SECTION 75W MODIFICATION TO THE REDOX CHEMICALS WAREHOUSE, MINTO

Our Reference: SYD18/01249/02 (A24108379)
DP&E Ref: DA 367-11-2002-I MOD3

SECTION 75W MODIFICATION - THE REDOX CHEMICALS WAREHOUSE, MINTO

Figure 1: Locality site showing Proposed Heavy Vehicle Haul Route

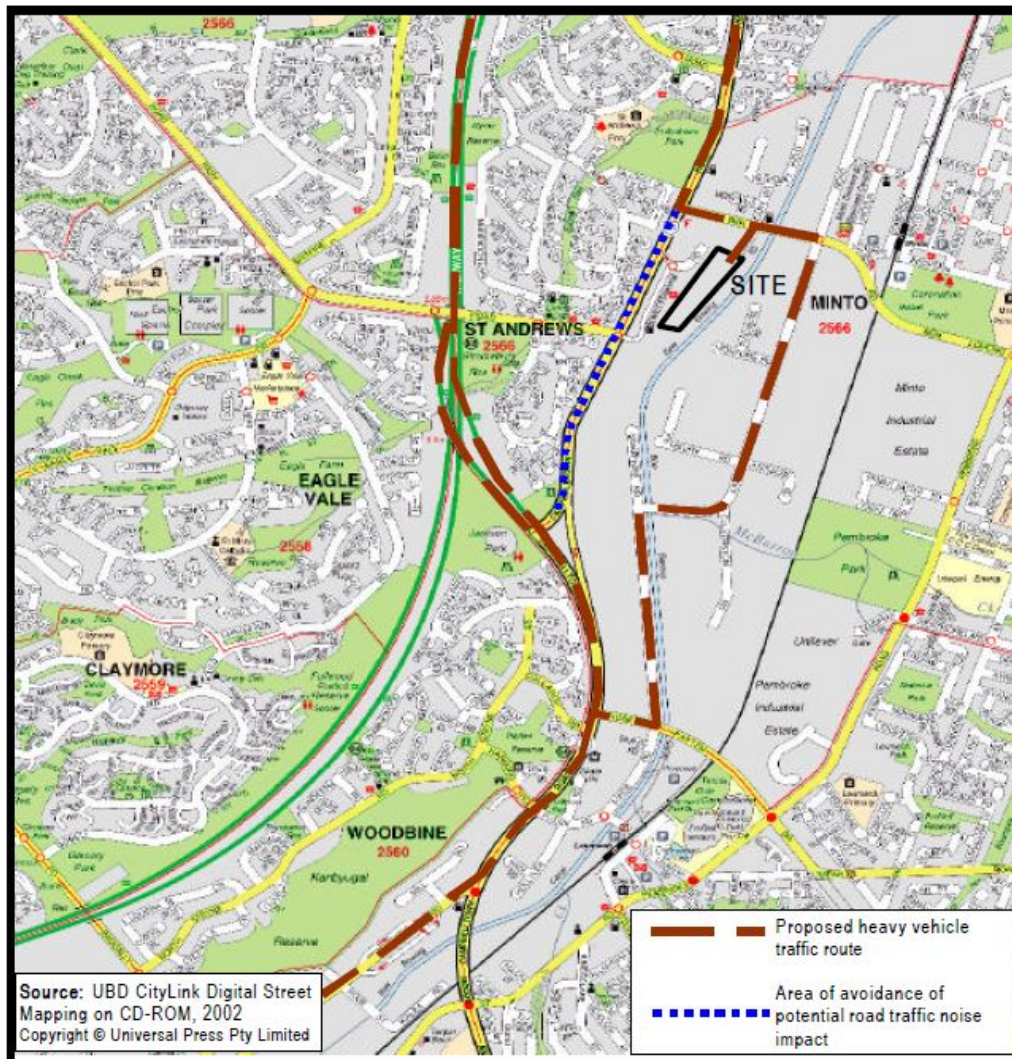
1. The modification of the heavy vehicle route is not considered justified via the "*Traffic and Parking Impact Assessment Report*" prepared by Transport & Urban Planning Pty Ltd, dated August 2016, which deals mainly with vehicle numbers and movement corridors. The proposed change of route appears to traverse greater residential areas than the original route, see attached aerial map, and this requires greater consideration of local amenity impacts when assessing the suitability of any route variation;

2. Proposal requires greater environmental and safety assessment relating to the transport of hazardous materials through primarily residential areas and details of hazardous risk assessment analysis undertaken;

Figure 4-5: Existing Truck Route

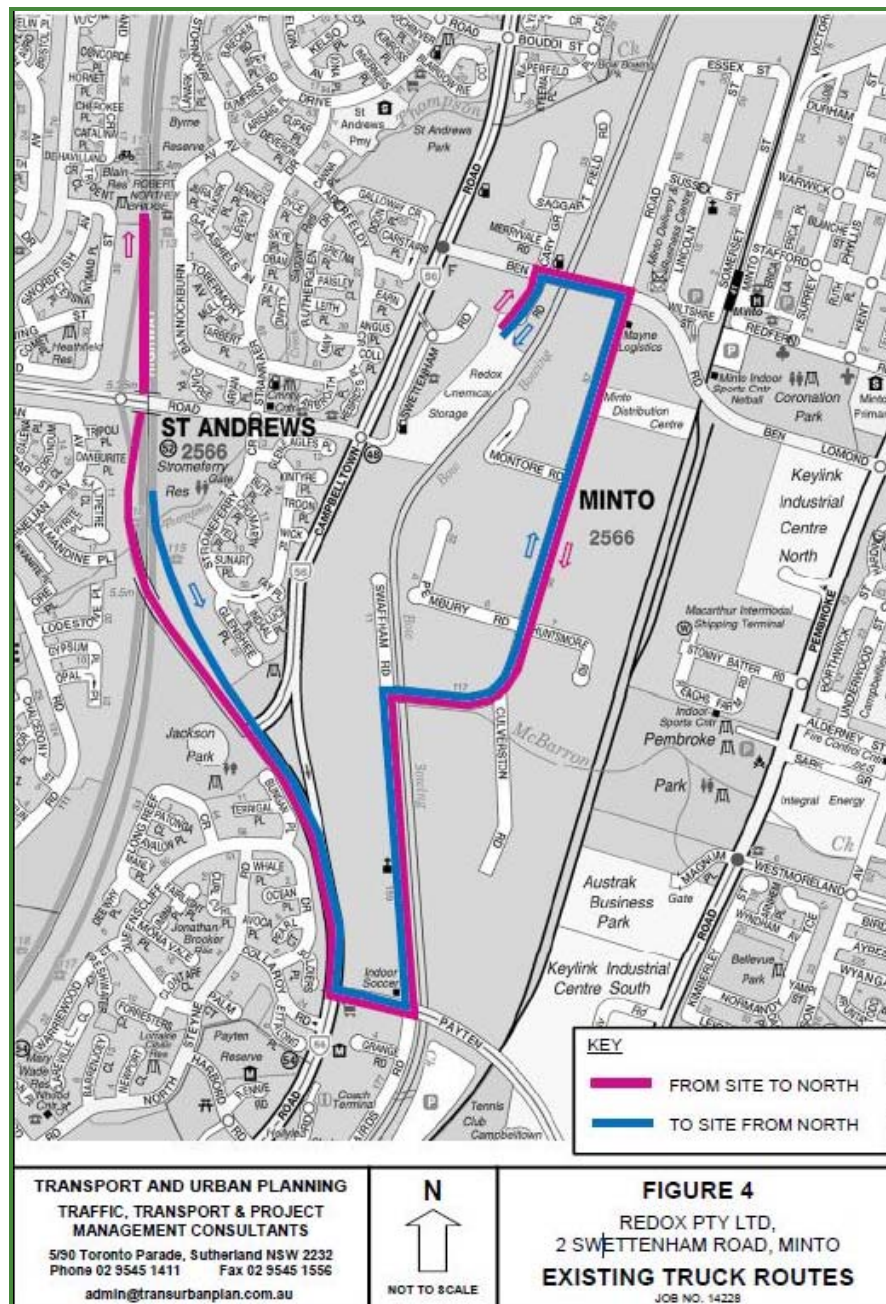
3. Any assessment of the modification to the approved transport routes servicing the facility should have regard to the intent/purpose, applicability and necessity to modify, the following transport related conditions of the 2003 approval for DA No.367-11-2002-i issued by the NSW Minister for Infrastructure and Planning:
Conditions 1.1, 1.2, 4.6, 4.9, 4.10, 4.11, 4.21, 4.22, 5.2, 5.6, 5.10, 7.4 and 7.5
